Our ref: Gregory Place Build-to-Rent (SSD-31179510)

Subject: Response to Submissions

ATTACHMENT 1 – KEY ISSUES

FIGURE No. **08**

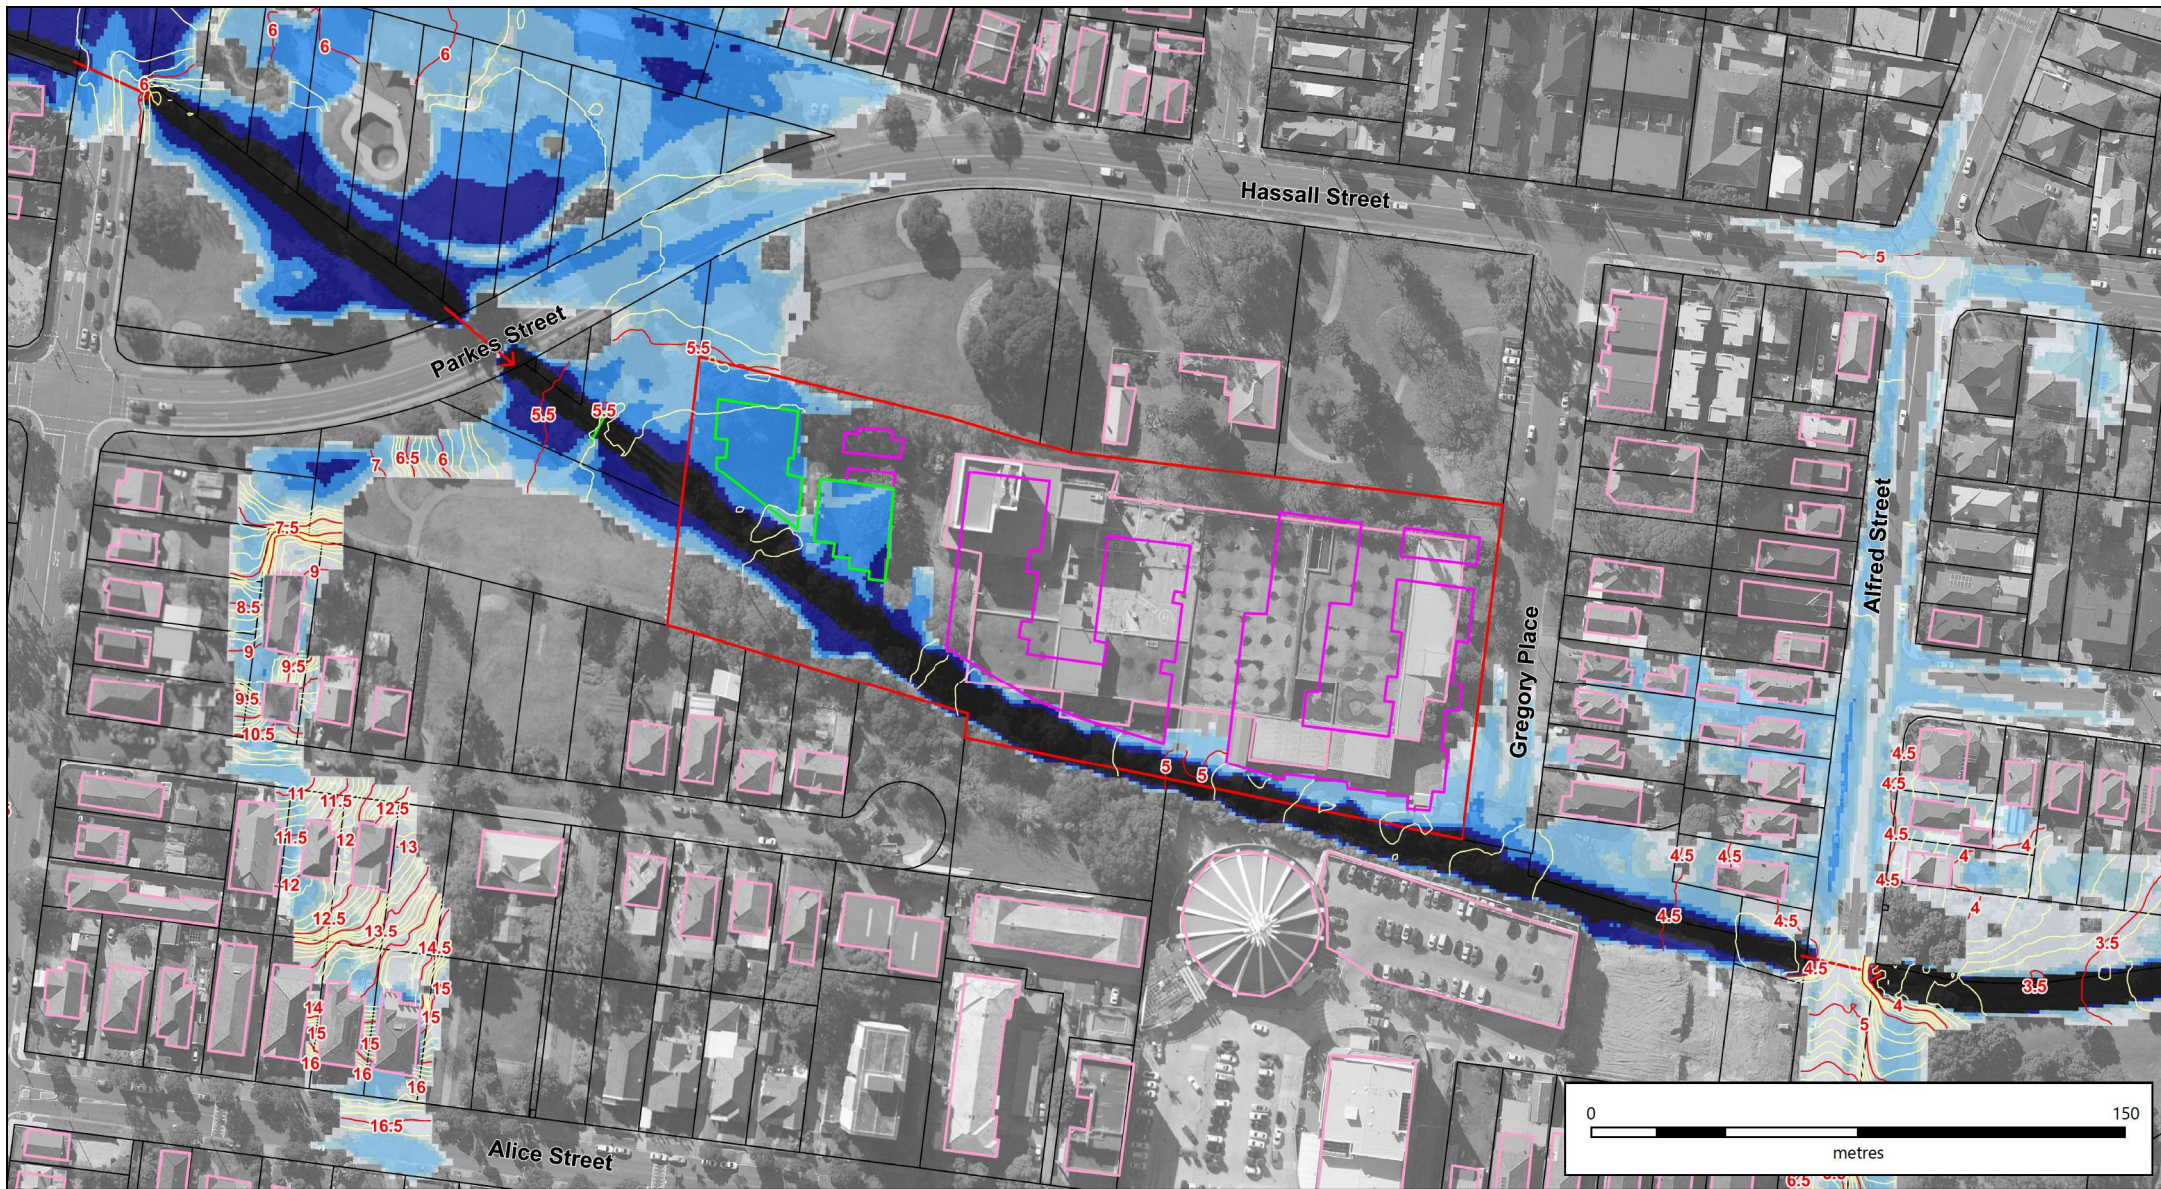
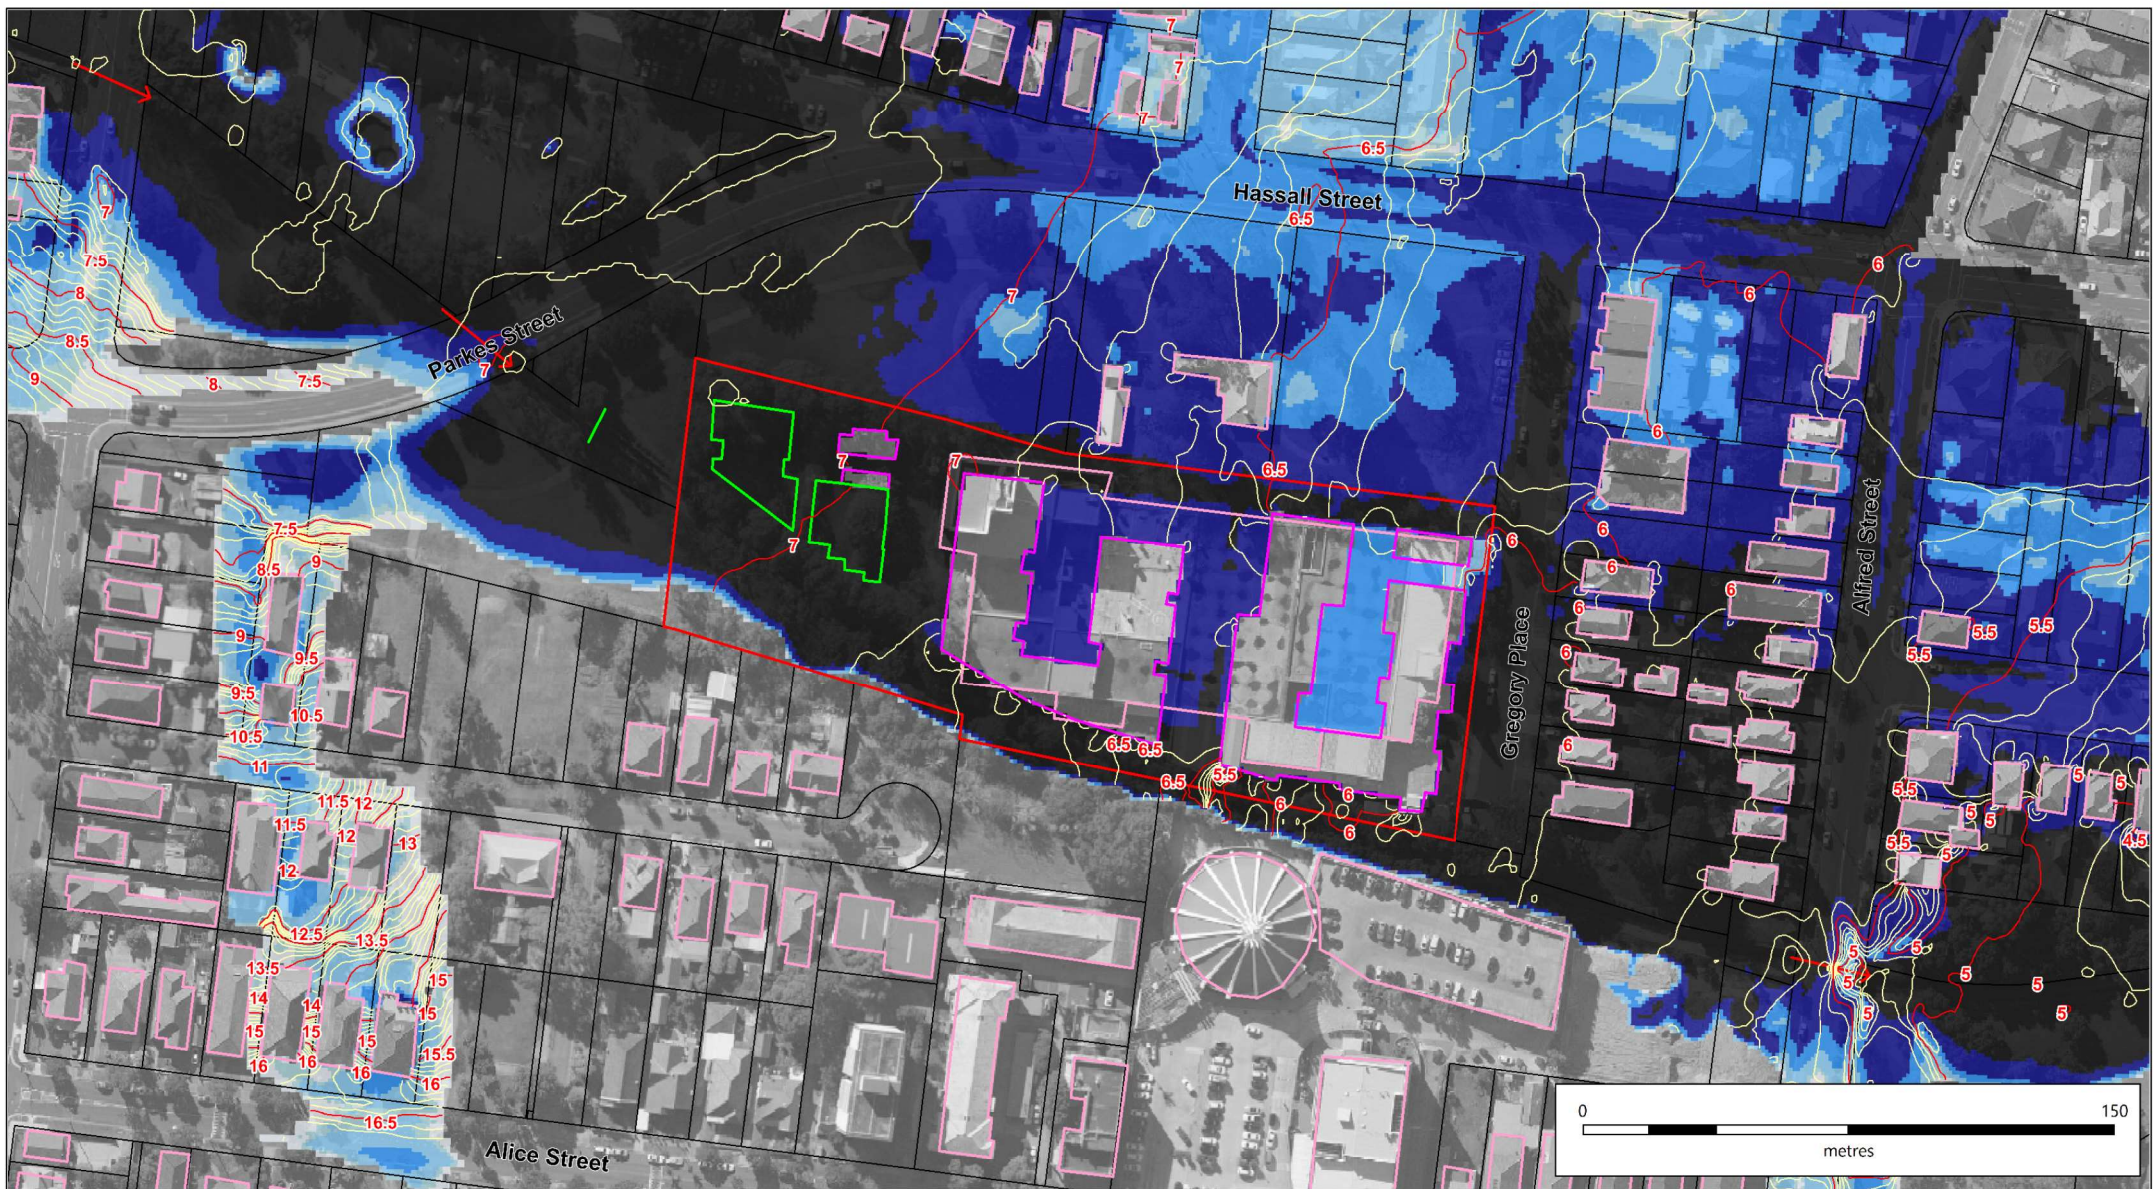
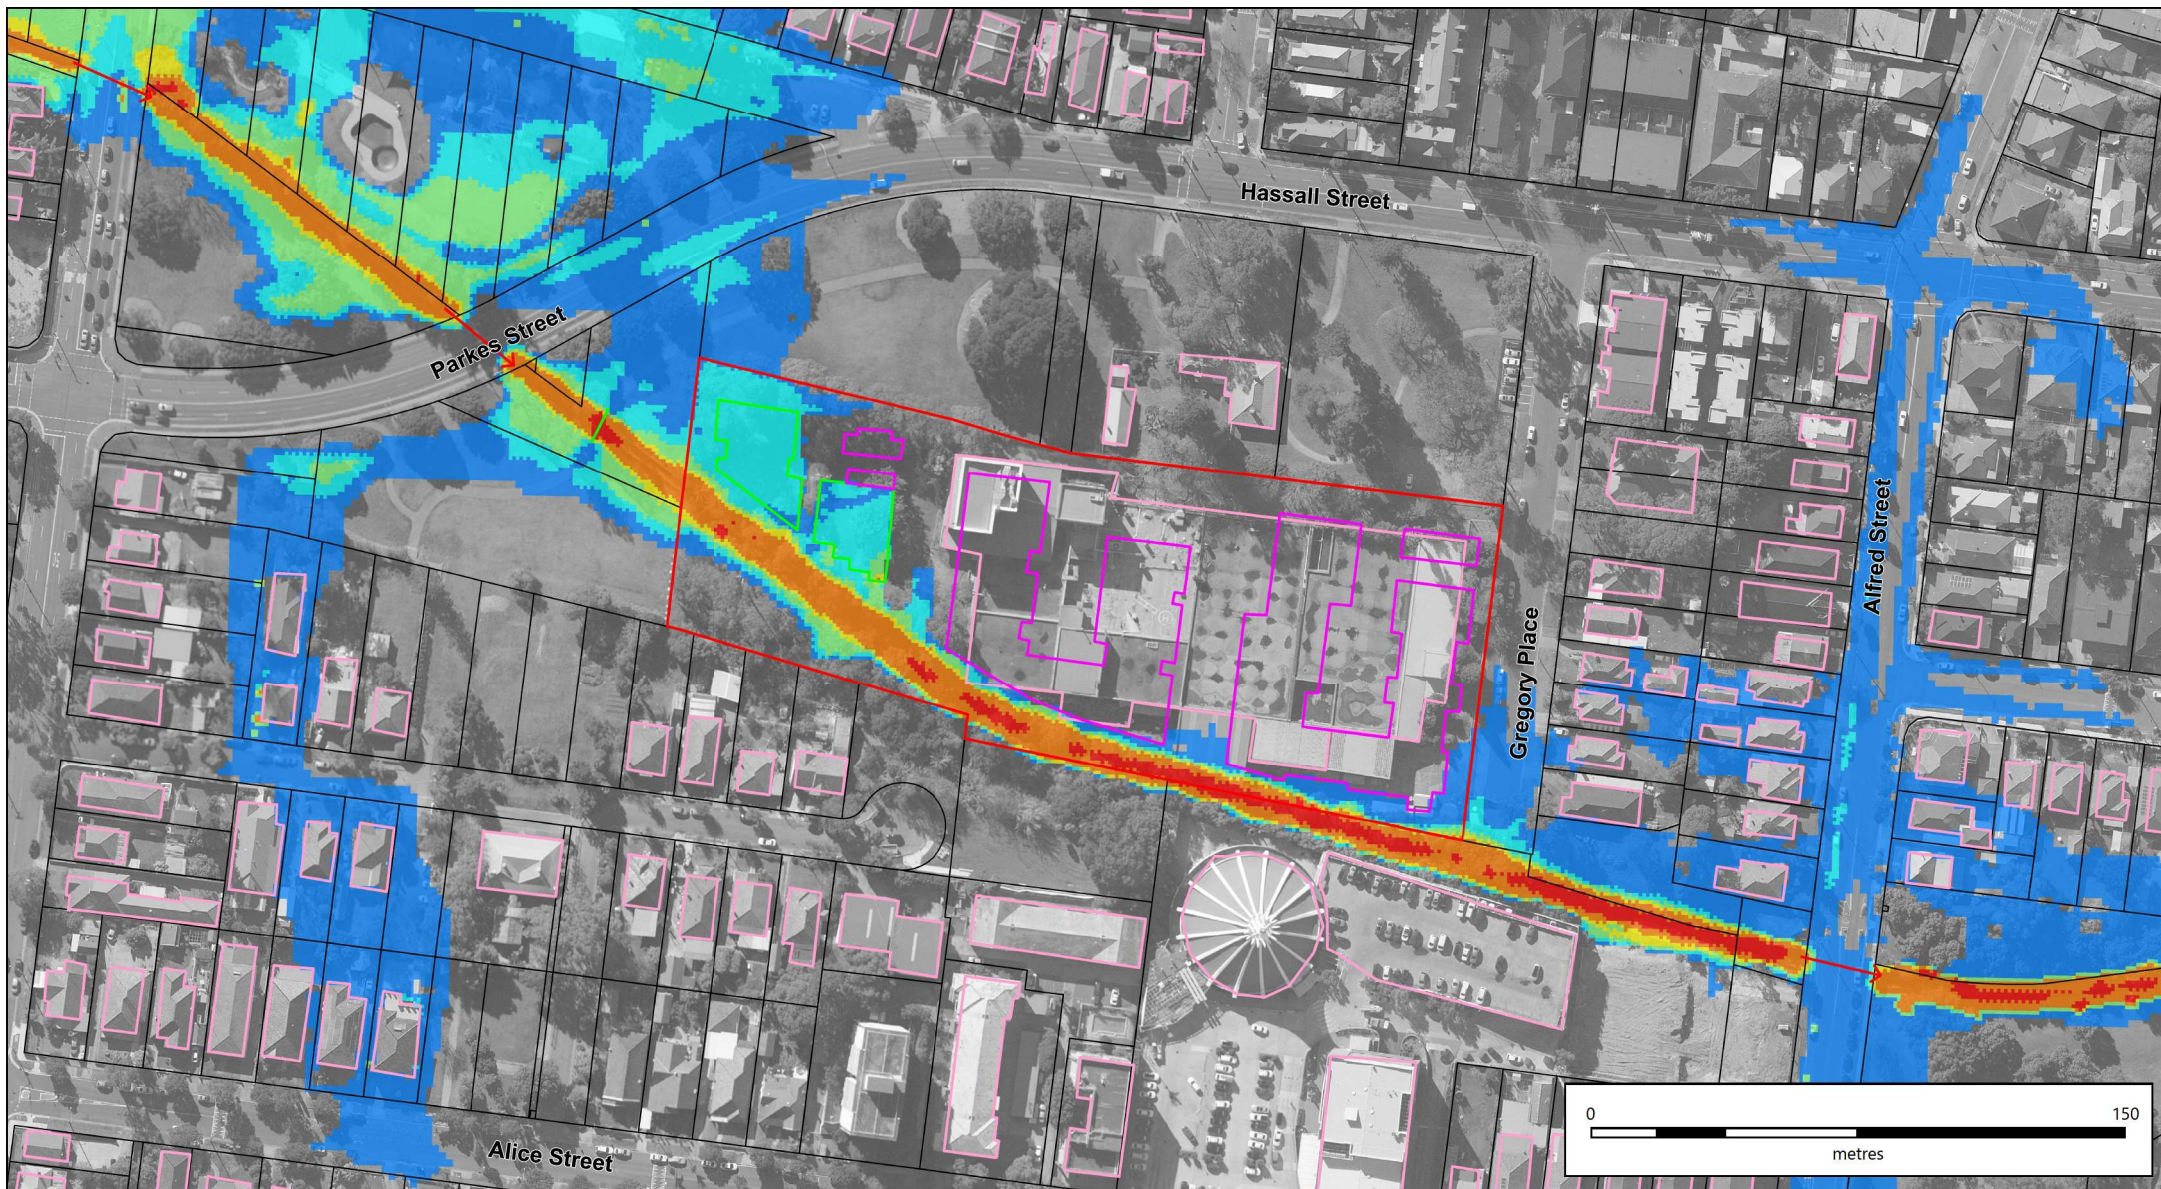
- There appears to be inconsistencies between the flood modelling provided in the flood report and council's adopted flood maps. The modelling must be updated to take into consideration council's adopted flood study levels. Any revised modelling should also address the site's classification as being within a 'High Flood Hazard Area' including consideration of the structural integrity of the proposed building within the identified hazard area. The revised modelling should also consider blockage factors, overland flows and climate change.

- Provide flood details for each individual stage of development. For example, how would a 1% AEP flood impact the development if only Stage 1 was completed, and no additional flood storage was present.

Figure 6.2: Future interpretation opportunities for the location of 'Neale's cottage' and Clay Cliff Creek within the proposed redevelopment (Taylor Brammer Landscape Architects Pty Ltd 2021)

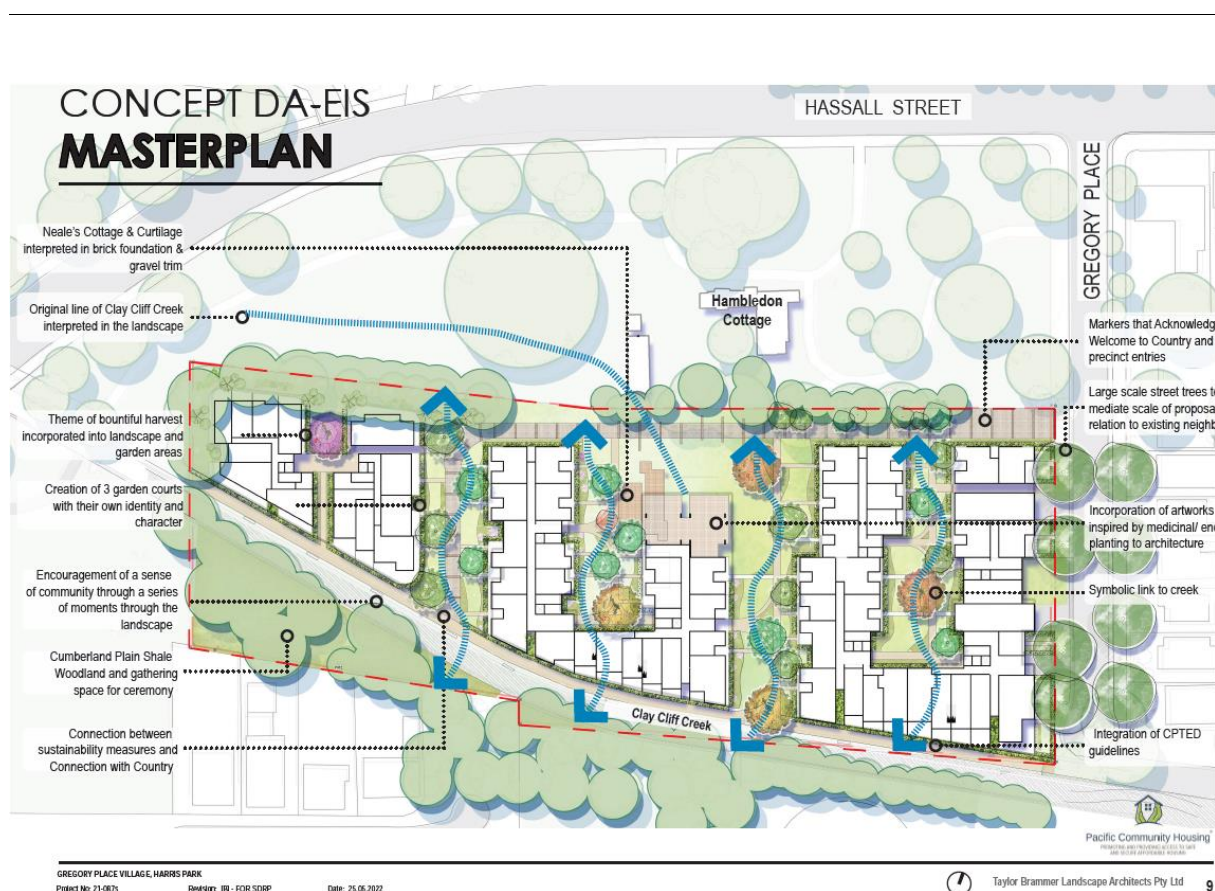
- The original line of Clay Cliff Creek appears to be shown at different locations within the landscape plan (pages 3 and 4 differ from pages 9 and 9). Provide a more detailed discussion on how the original line would be interpreted into the landscape design.

Figure 1: 2022 Concept footprints

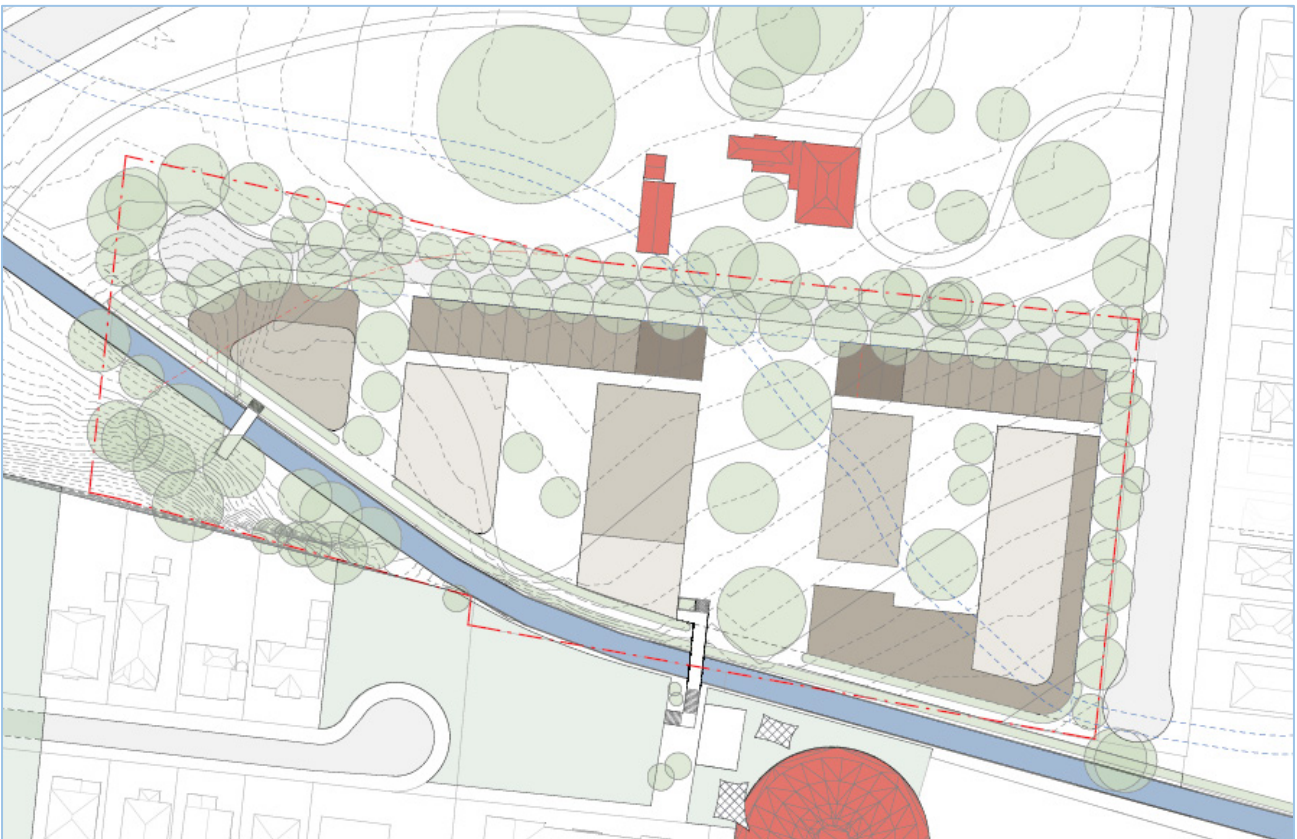
- The proposed height of buildings and Clause 4.6 request are not supported by the Department in their current form. The scale and height of the concept development are not in keeping with the character of the area. The proposed building height would result in overshadowing of an adjacent childcare centre, potential privacy issues and potential heritage impacts to nearby items. It is requested that the buildings be reduced in height and scale to adequately respond to the constraints of the site.

- The shadow diagrams submitted with the EIS indicate that the creek corridor walk would have substantial overshadowing during winter. This, combined with narrow setbacks and long buildings are likely to result in poor amenity for its users. Provide amended plans with increase setbacks to Clay Cliff Creek and increased sunlight access to the corridor walk during mid-winter. Alternatively, discuss why this cannot be reasonably achieved and alternative measures to ensure a high level of amenity would be achieved by the development.
